CITY OF ALBUQUERQUE

October 20, 2021

**RE: Tract "A" Southwynd Subdivision
Grading and Drainage Plan
Engineer's Stamp Date: 08/15/21
Hydrology File: L10D020A**

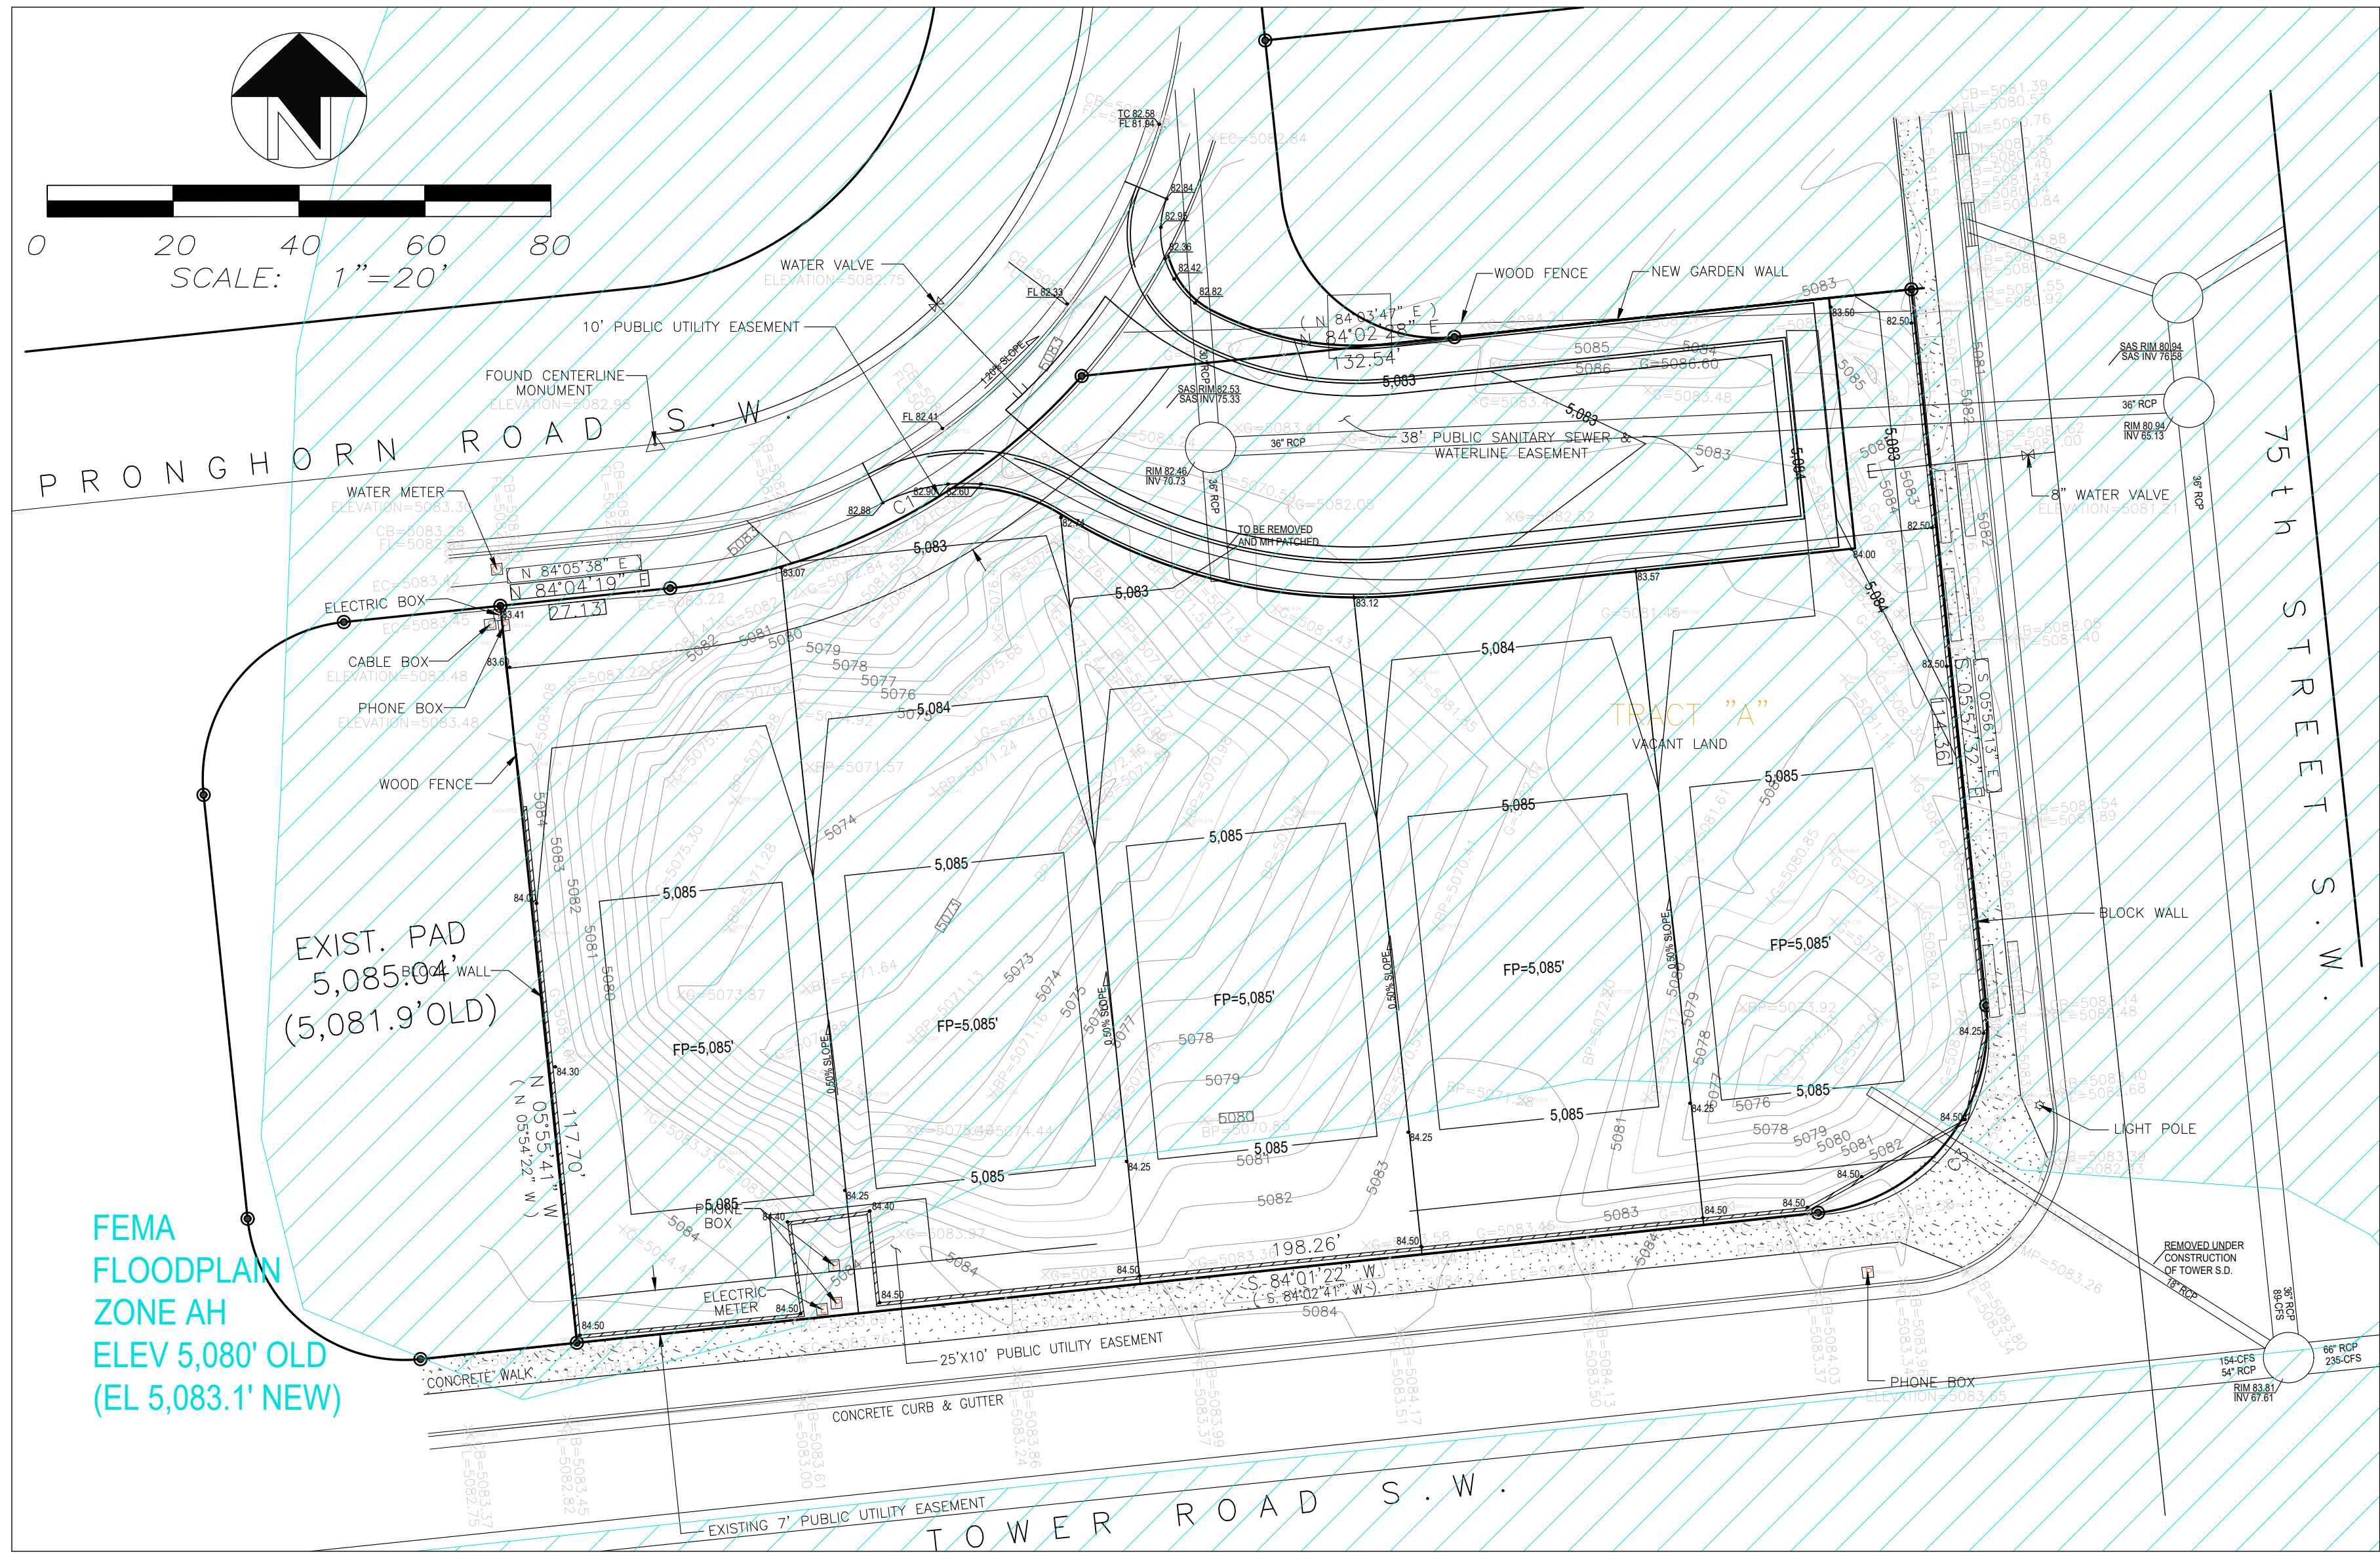
1. This submittal is only for filling in the existing detention pond and creating a gently sloping tract of land from Tower to Pronghorn. So basically the final product for Tract A should then be a general blank piece of property.
2. Please place the existing floodplain on the Grading Plan.

3. Since this will be just a simple grading plan, the calculations should be able to fit on one sheet with the grading.
4. Standard review fee of \$150 will be required at the time of resubmittal.
